December 30, 2014

**RE: Revised Grading Plan (C-17D122)
Kirkpatrick Warehouse
Albuquerque, New Mexico**

December 23, 2014

**Re: Kirkpatrick Warehouse
Kirkpatrick Warehouse Drainage Report with Engineer's Stamp dated 11-25-14
Kirkpatrick Grading and Drainage Plan with Engineer's Stamp Dated 12-22-14
(C17D122)**

# DC-780 TECHNICAL SPECIFICATION

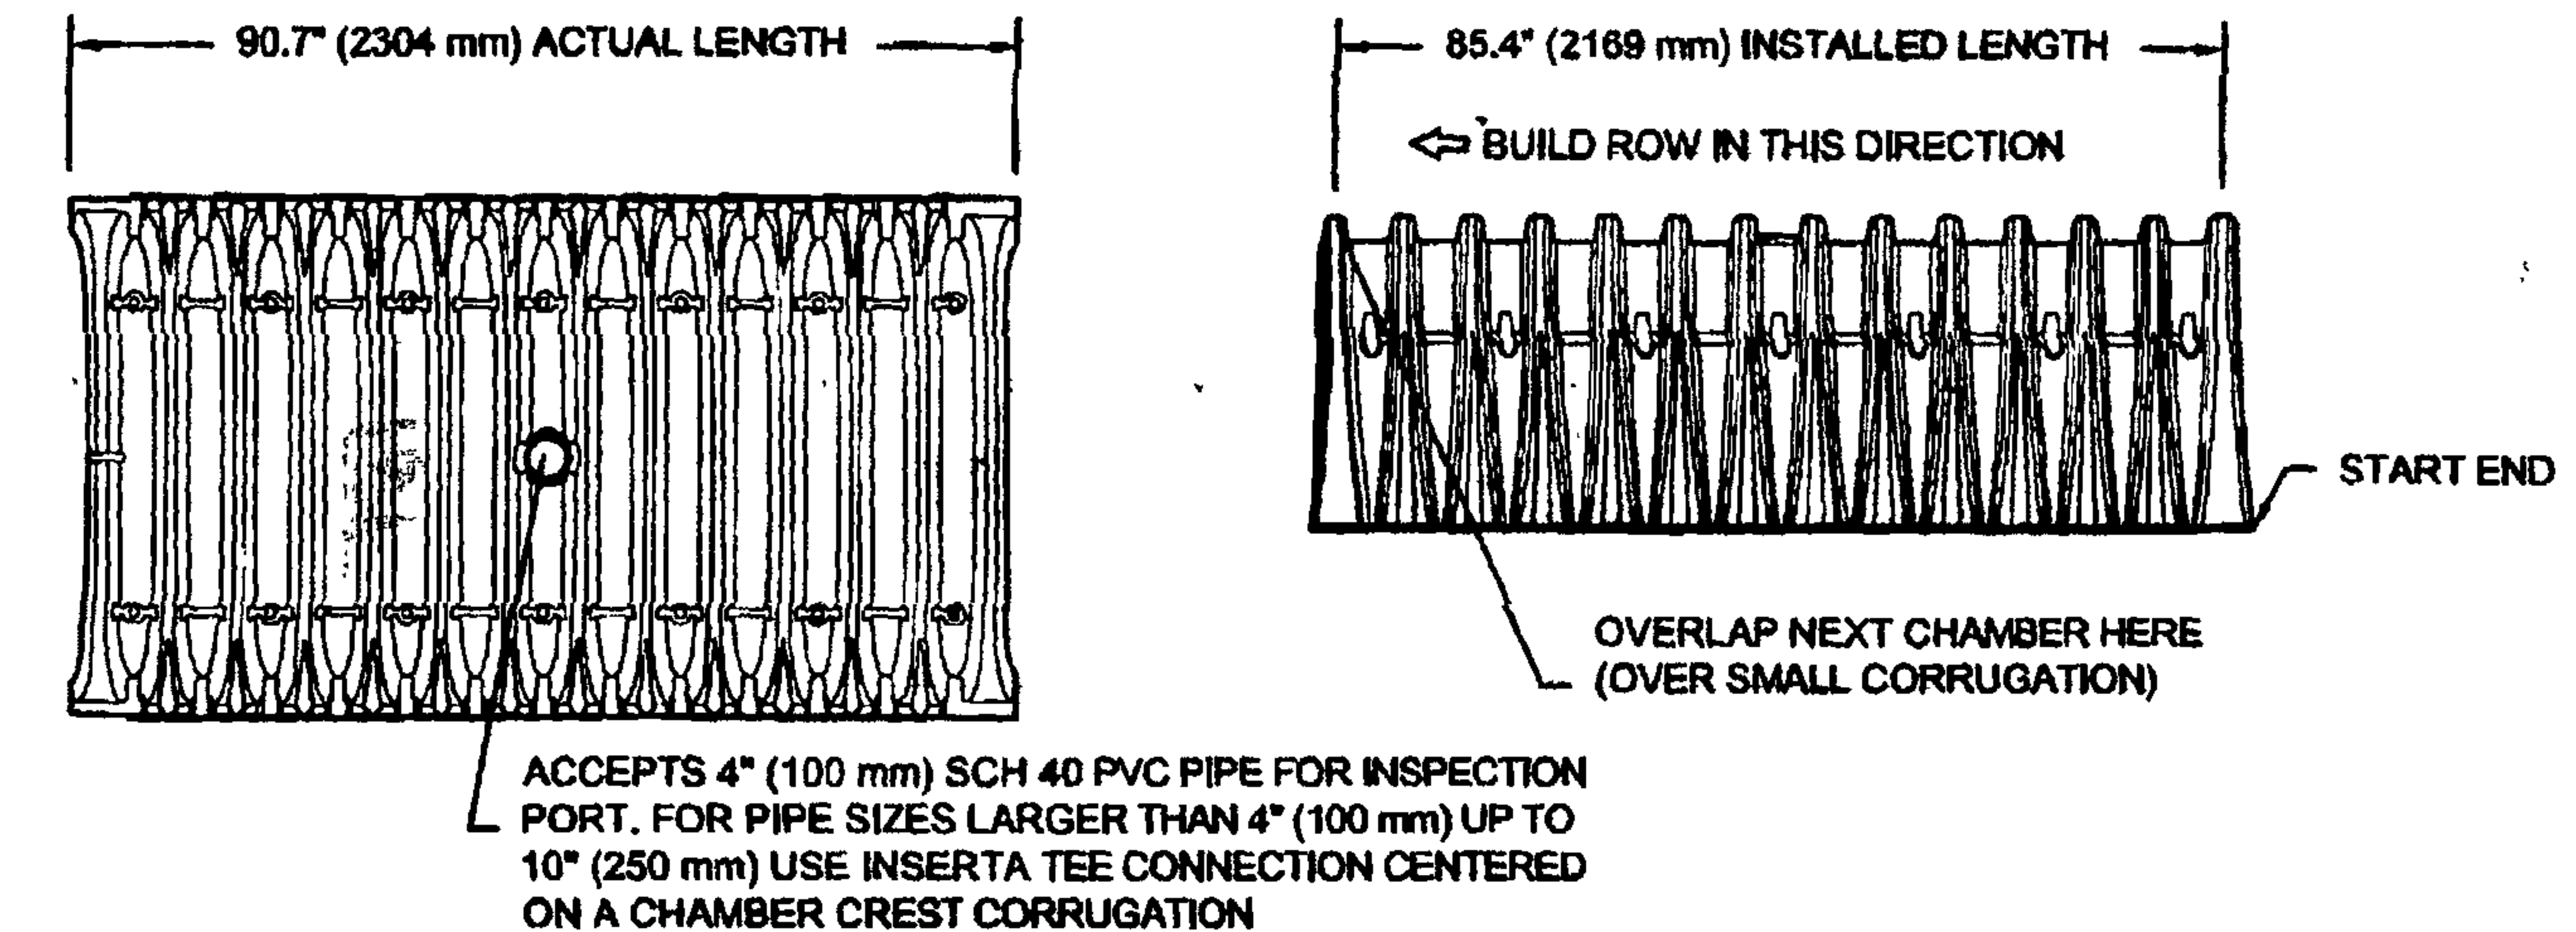
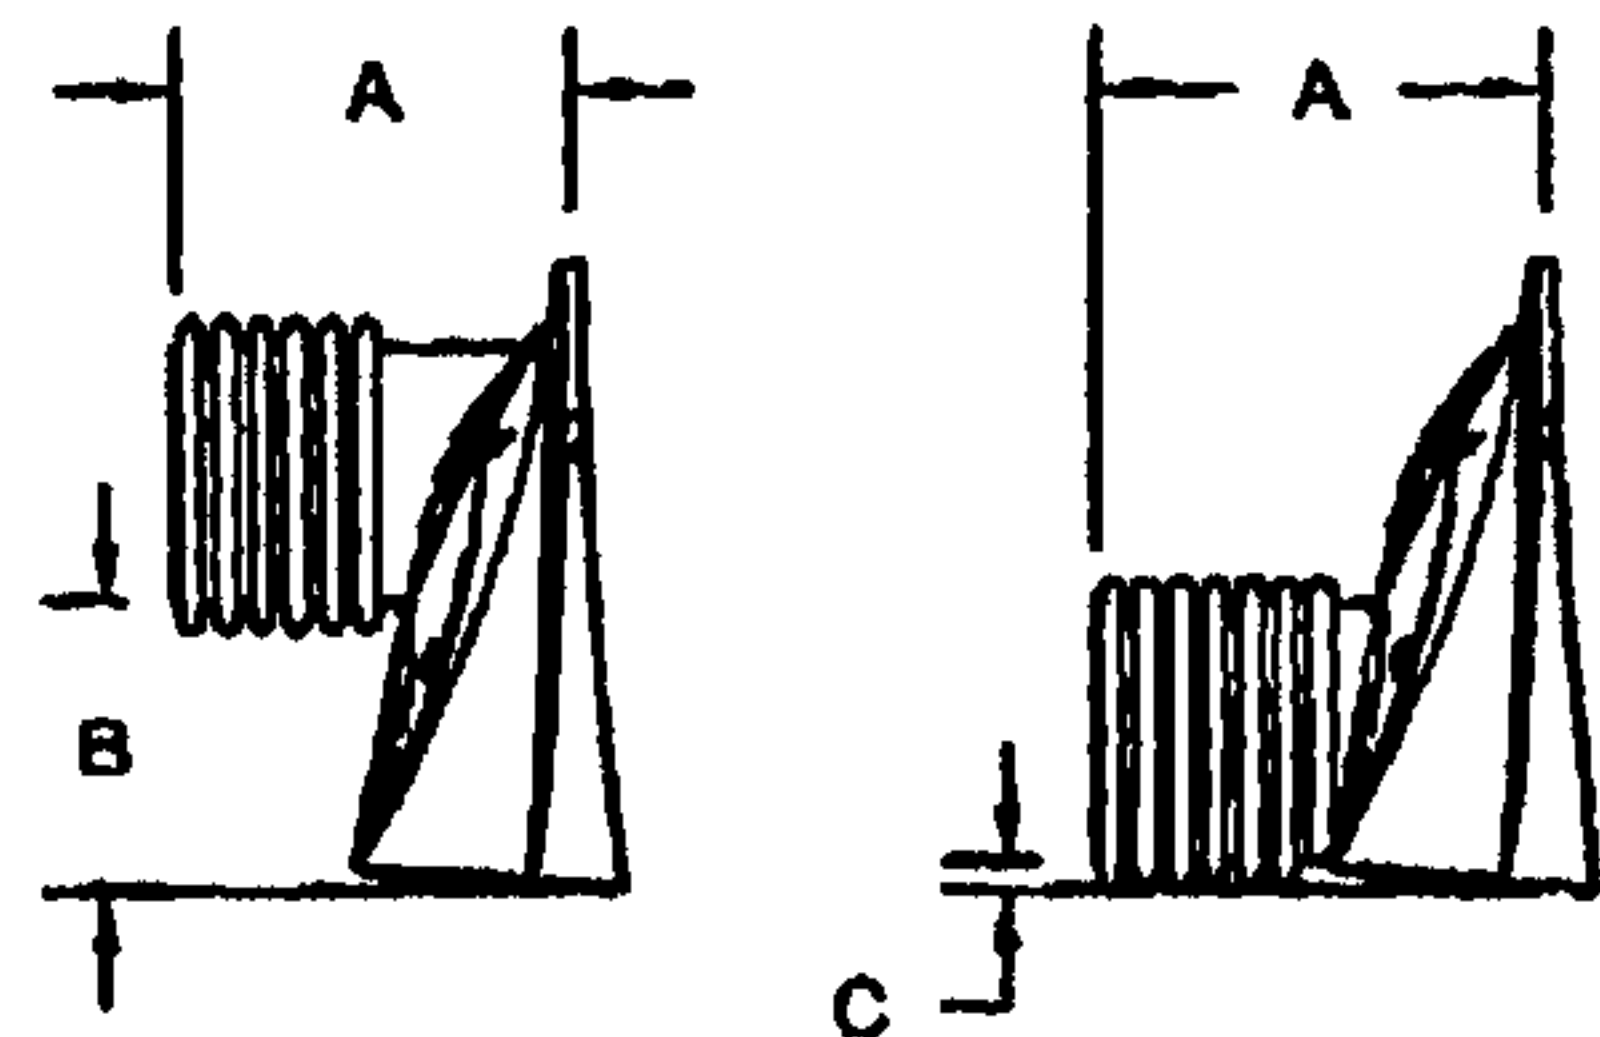
1. Provide calculations for storm tech.

1. Include calculations for the design of the Stormtech system.
2. Provide a detail sheet for the Stormtech system that includes plan and profile views.
3. The inlet grate is at 94.25 but the invert is at 59.75. What should the invert really be at?
4. How will the manifold system be set up? How far apart are the rows? How will flows go into the isolator row? How will the isolator row be maintained and cleared of debris?
5. You have specified S780. Do you mean DC-780? What stub are you specifying?
6. What are the depths and type of stone for the whole system?
7. What kind of geotextile is being used? Where is the fabric located?

I have highlighted the volume for each chamber (78.4 cf) the drainage calculation sheet show division of the required volume of $2677/78.4 = 34$ chambers
